1st February 2011

Re-erection of period agricultural barn
Redundant Farm Buildings (South Lane Barn) South Lane Houghton

I regret that I am unable to accept your documents as a formal application until the following matters have been resolved :-

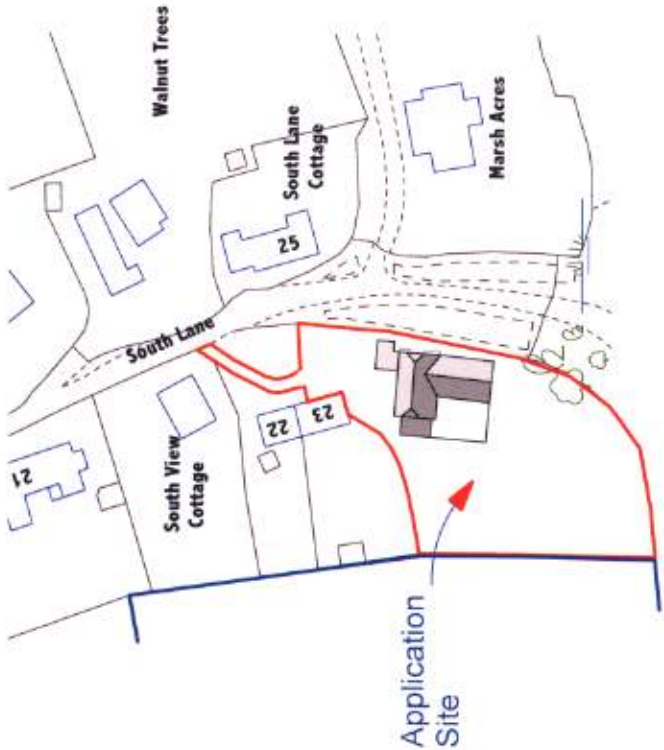
I require 1 electronic or 3 paper copies of a revised block/site plan showing the building(s) to be demolished marked as a dotted line, in accordance with the guidance notes available on our website detailed below (click on National List).

I require 1 electronic or 3 paper copies of a revised location plan showing at least one named road, in accordance with the guidance notes available on our website detailed below (click on National List).

Drawing number 10380/05 is labelled 'elevations proposed'. This should read 'location & block plans'. Please amend.
